COFFS HARBOUR CITY COUNCIL

Your ref: MP05_0129
Our ref: 3284722 (DA 0698/09)

RE: Exhibition of Preferred Project Report, Lakes Estate Residential Subdivision, North Boambee Road, North Boambee Valley (MP05_0129)

CHECKED	DRAWN	SCALE	
KS	DD	0 25 50 100 150m	
PROJECT NO.		DWG No.	REV. No.
912		A008	H

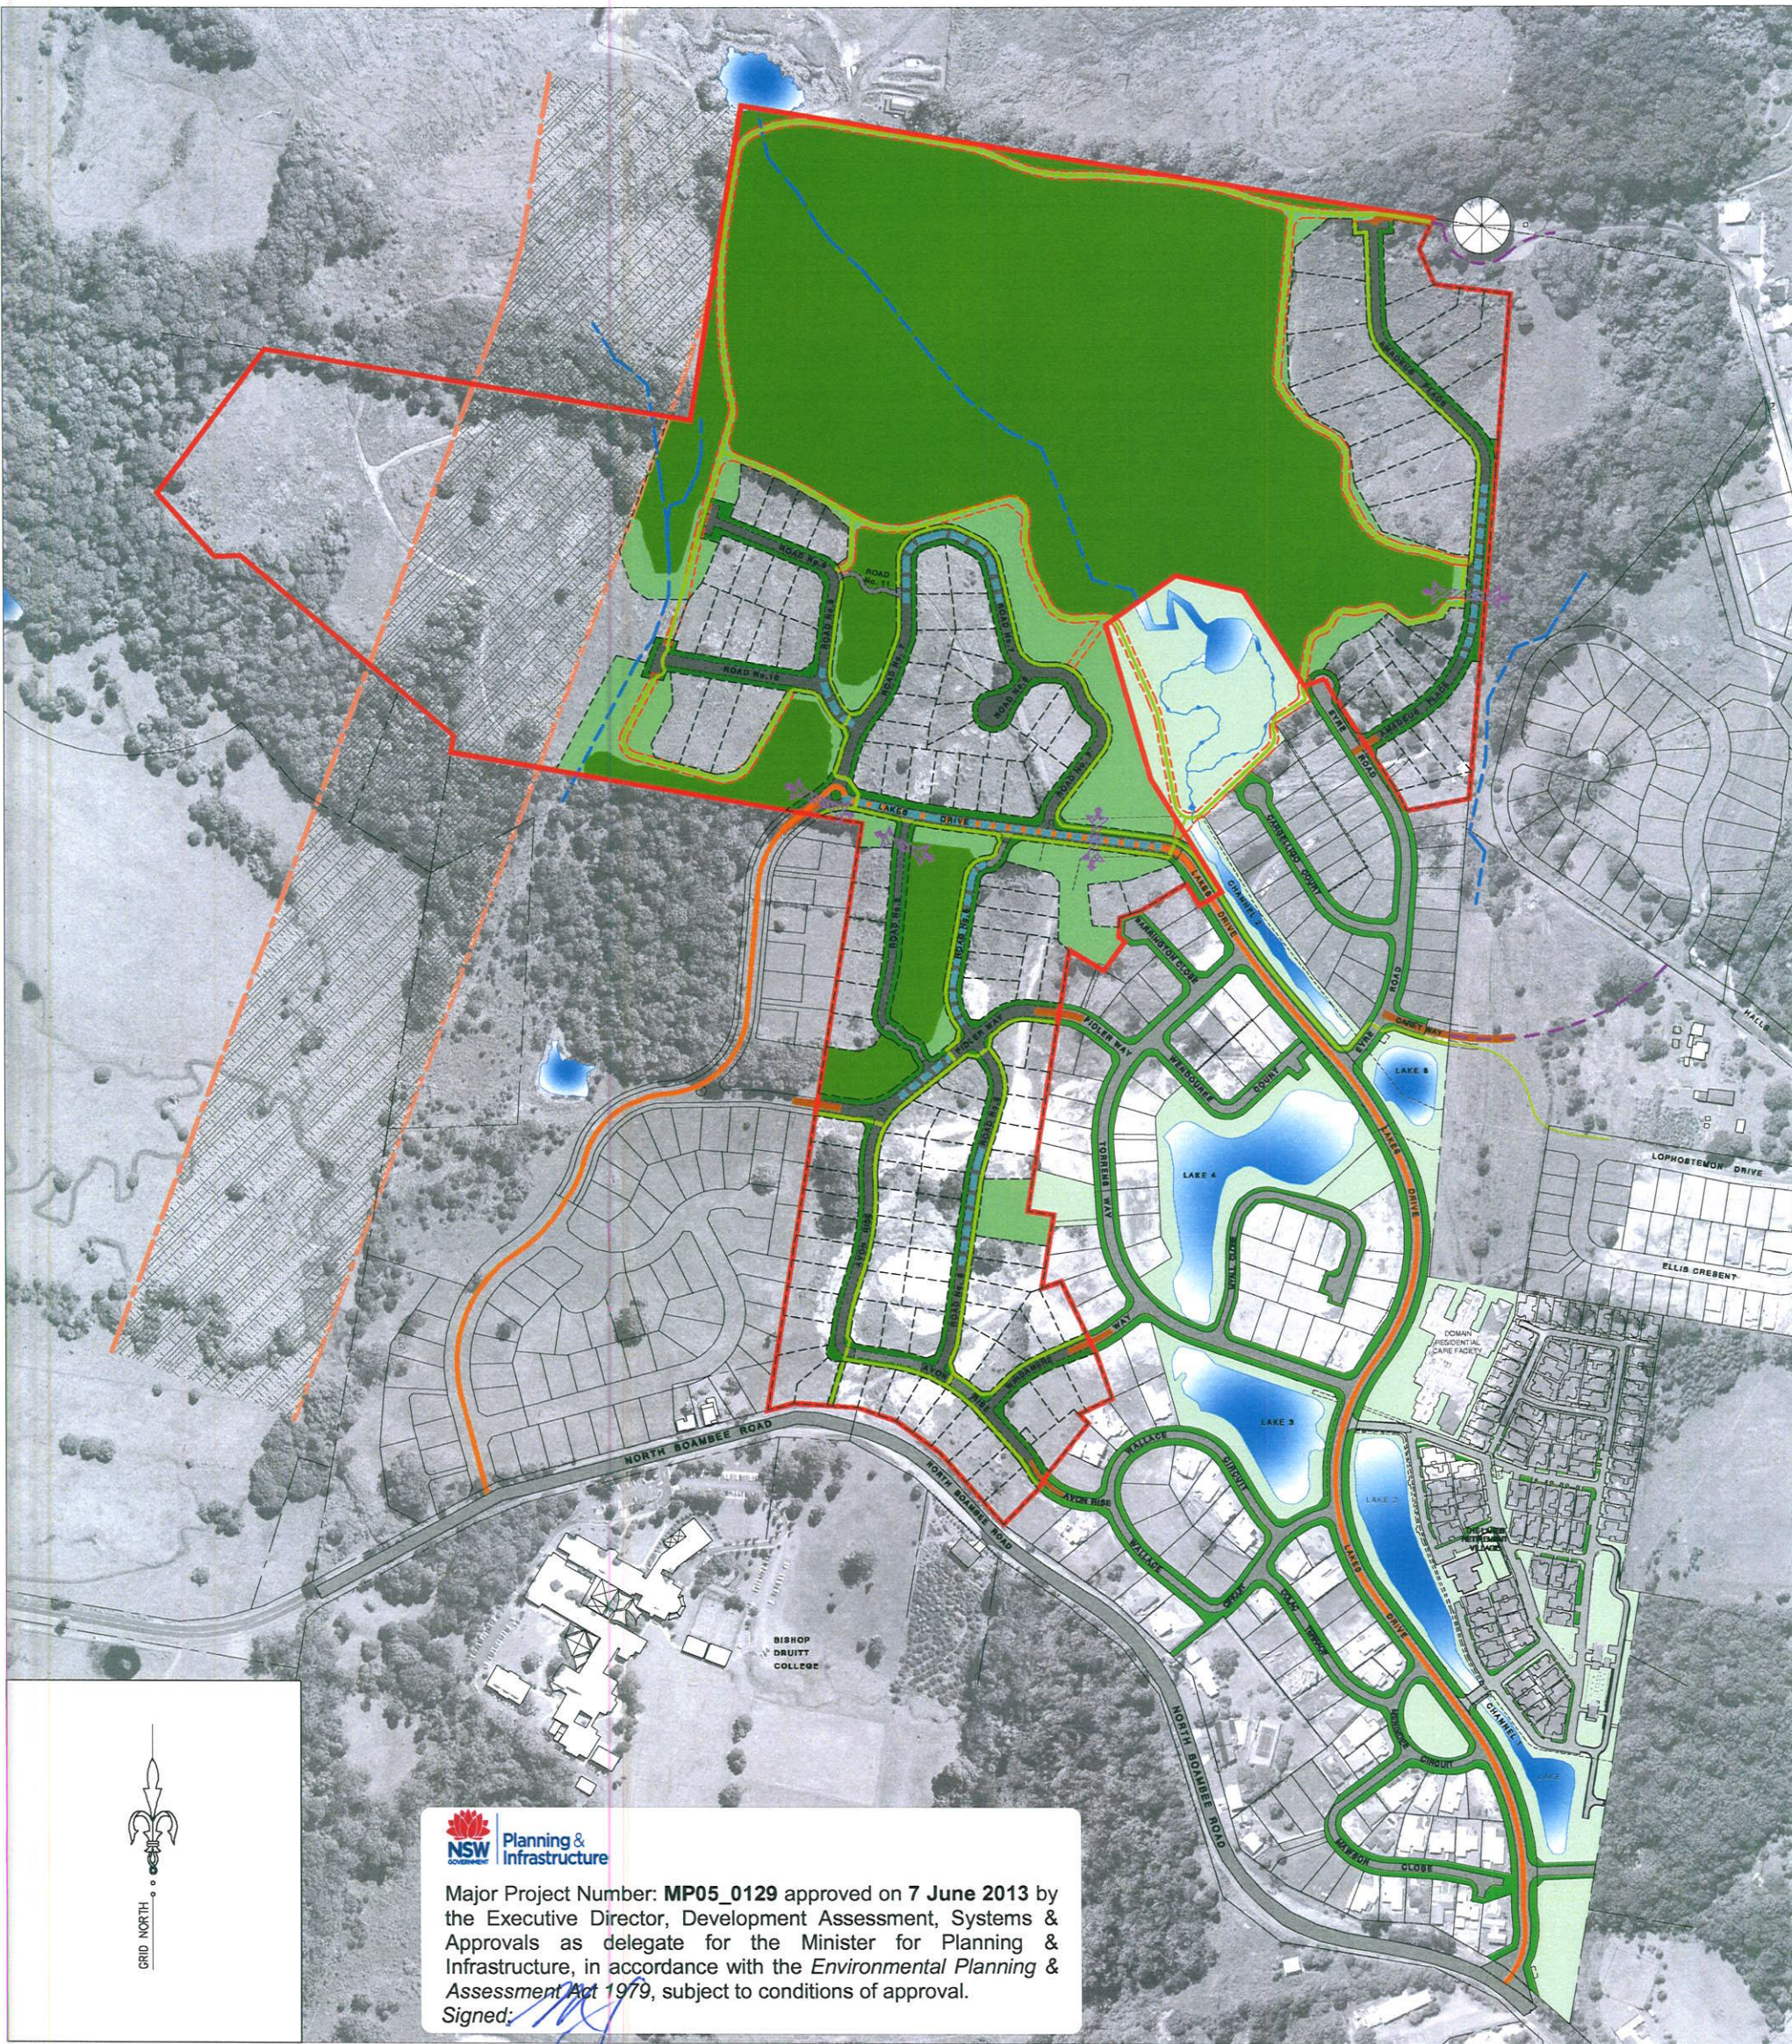
- The future road connection indicated on Drawing A008 (Revision G), extending Road No 3 to Kratz Drive, is not supported as it will dissect a future Council public reserve (Natural Area.) to be dedicated in conjunction with the adjacent subdivision.
